MY GARAGE @ NORTHCREST

COMMERCIAL CONSTRUCTION DRAWINGS

Kiowa
 Engineering Corporation
 1604 South 21st Street
 Colorado Springs, Colorado 80904
 (719) 630-7342
 PCD File No. SF-22-024

My Garage @ Northcrest
Site Detail Plan
Site Details
El Paso County, Colorado

1  
C601 Detention Basin Cross Sections  
NOT TO SCALE

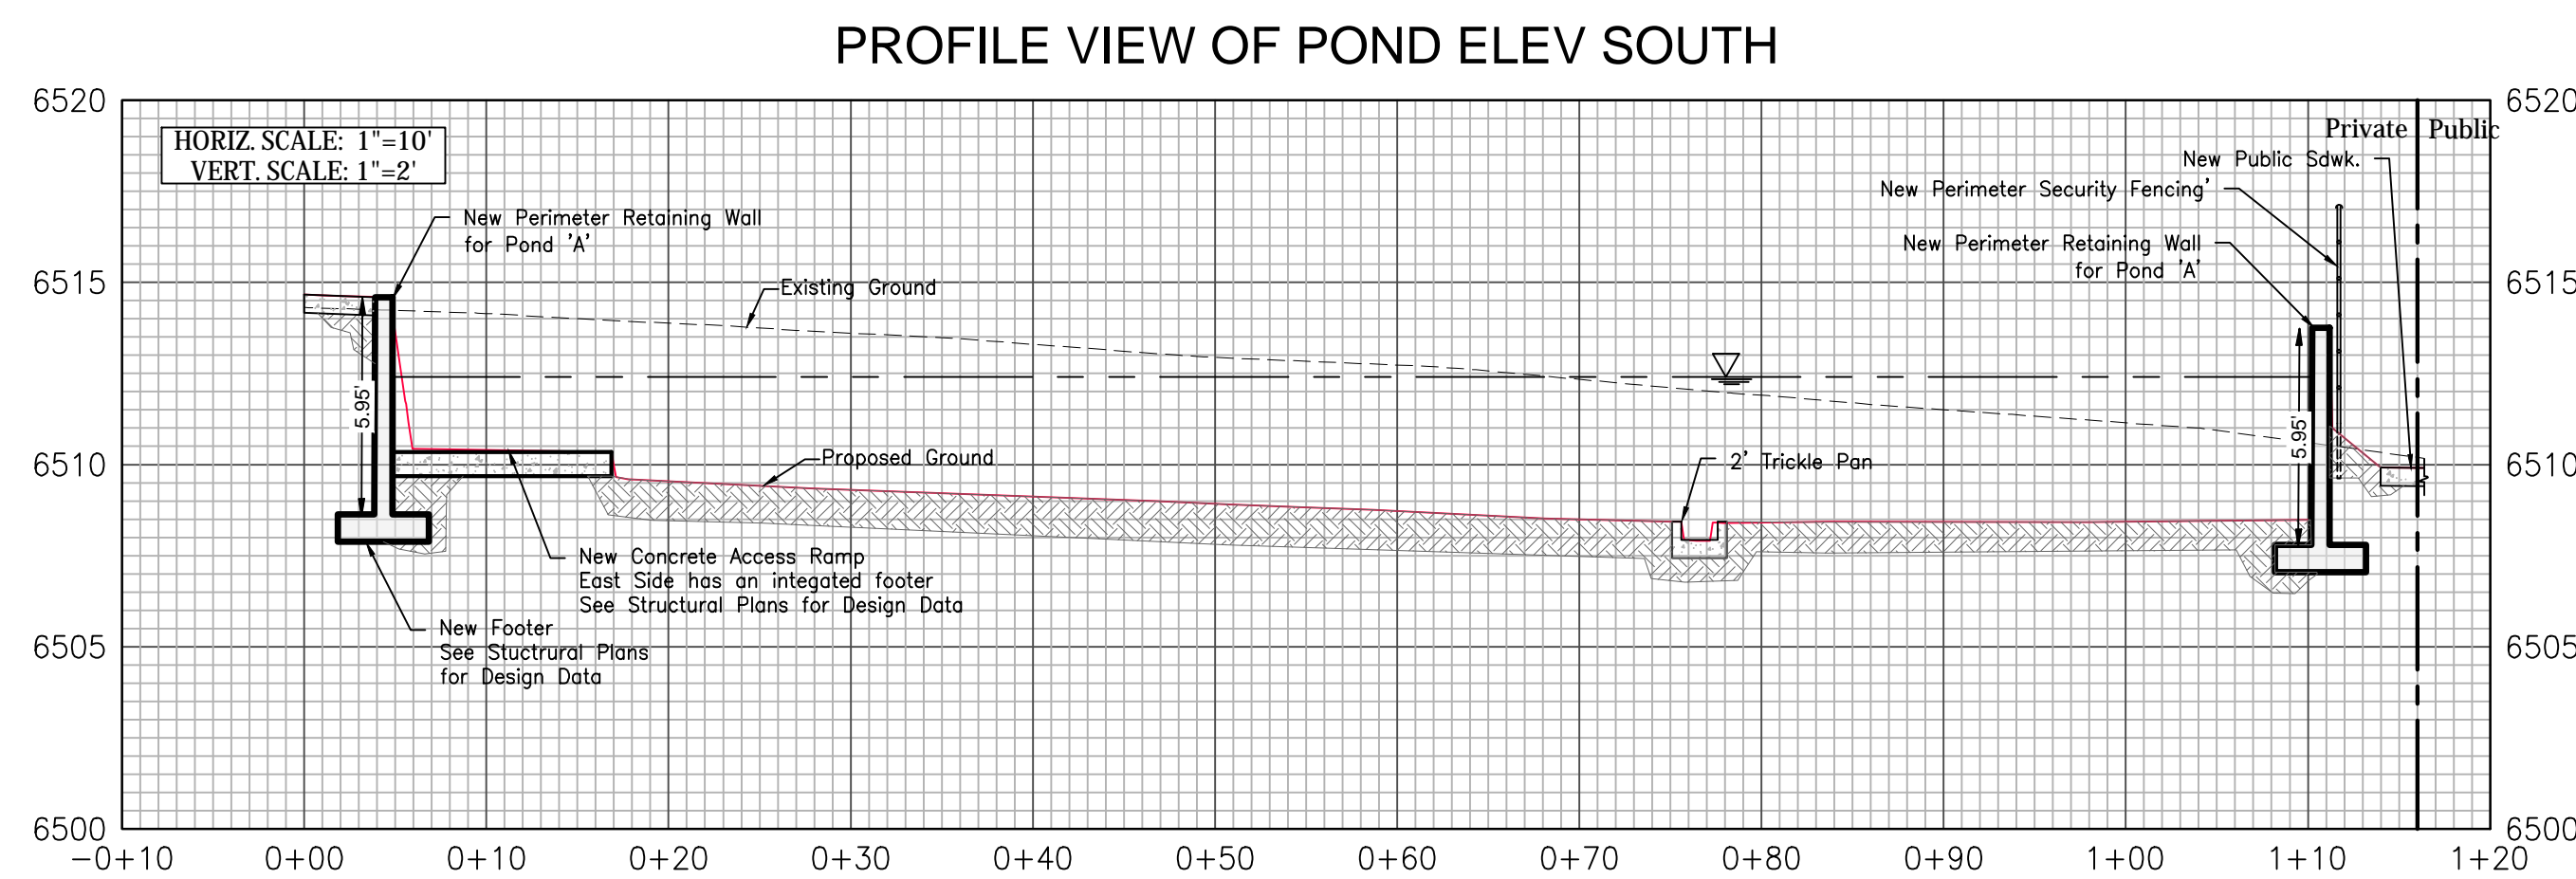
I'm not seeing the section markers for this section. Please show them.

1
C601 Detention Basin Cross Sections
NOT TO SCALE

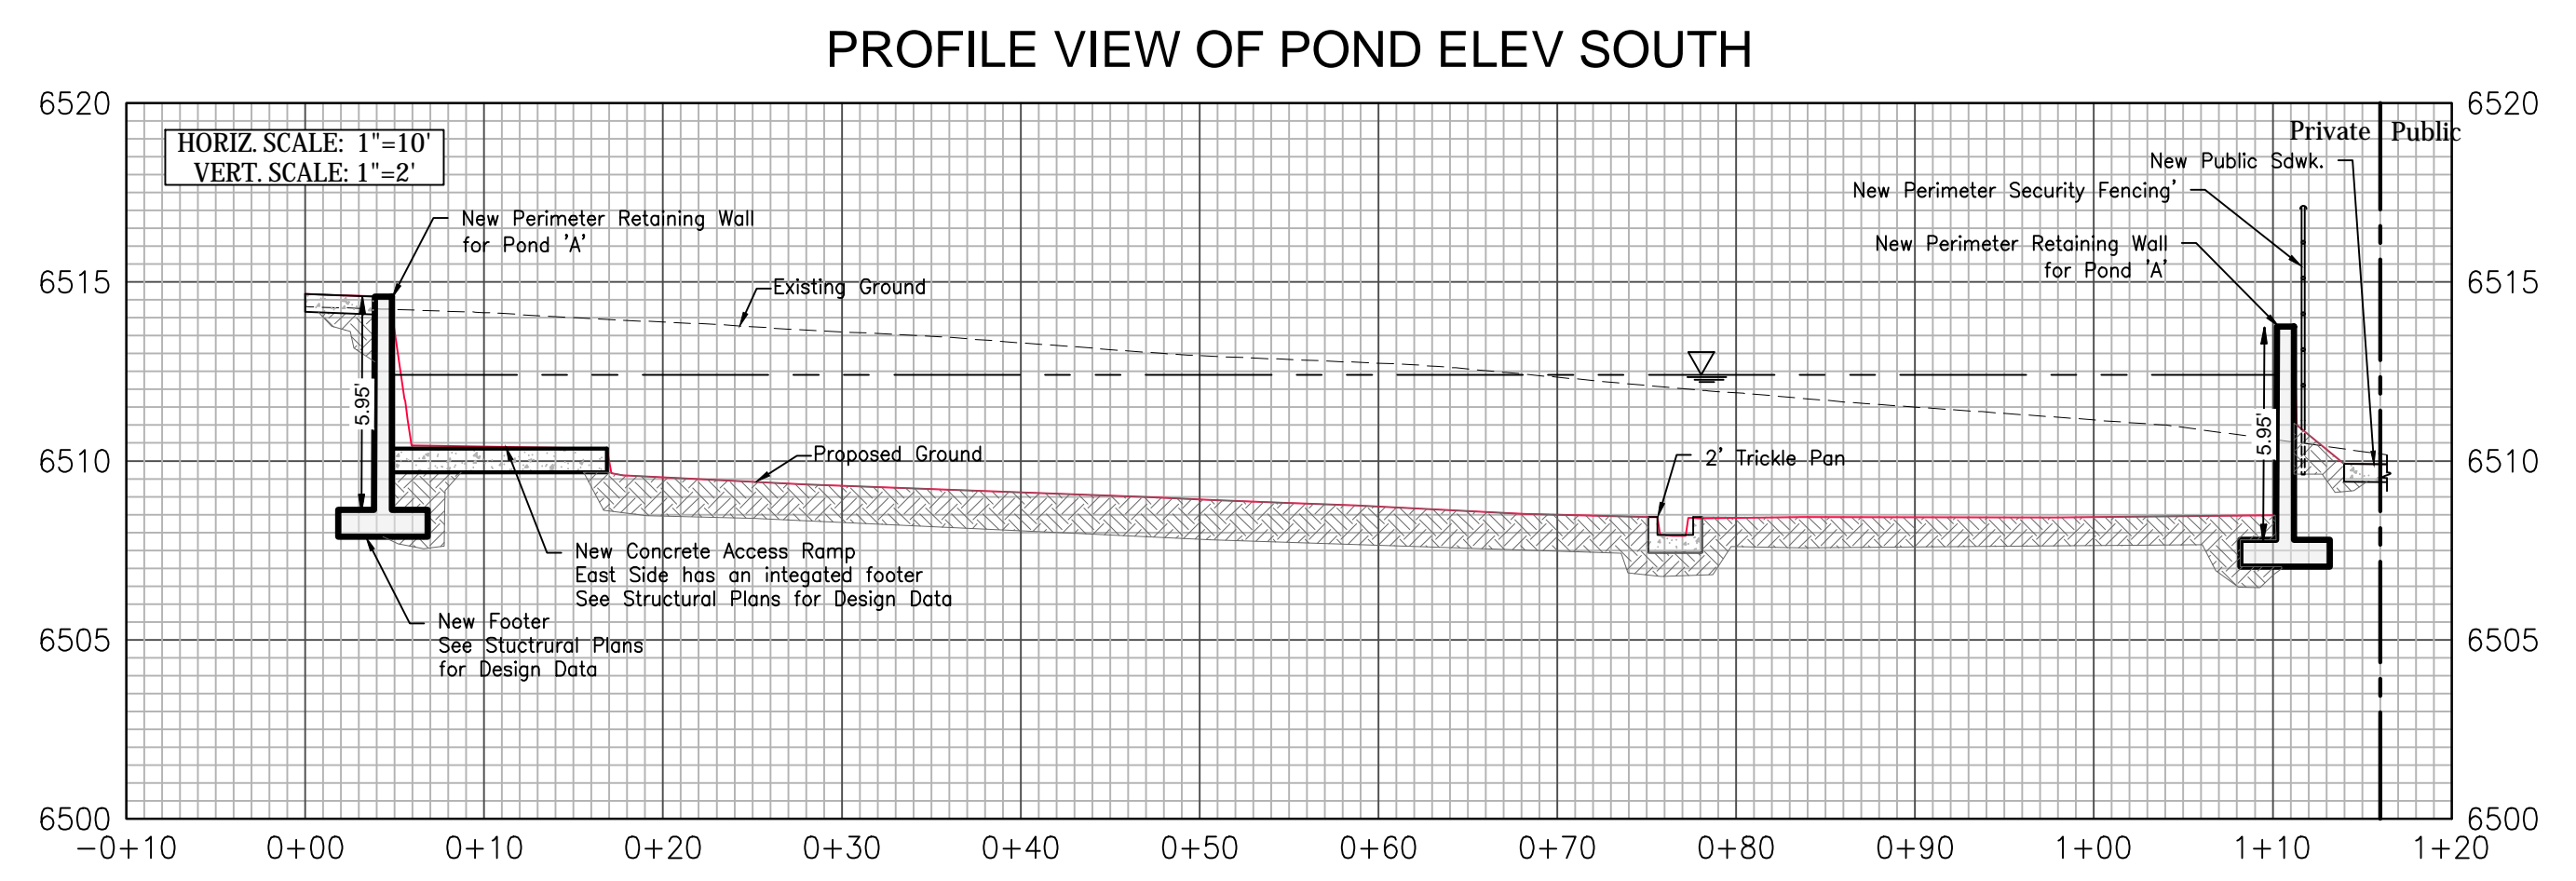
Unresolved Review 2 comment:
Pond bottom should have a minimum slope of 3%
to the trickle channel and micropool (USDCM Vol
3, detail T-5). Please adjust to minimize future
maintenance needs.
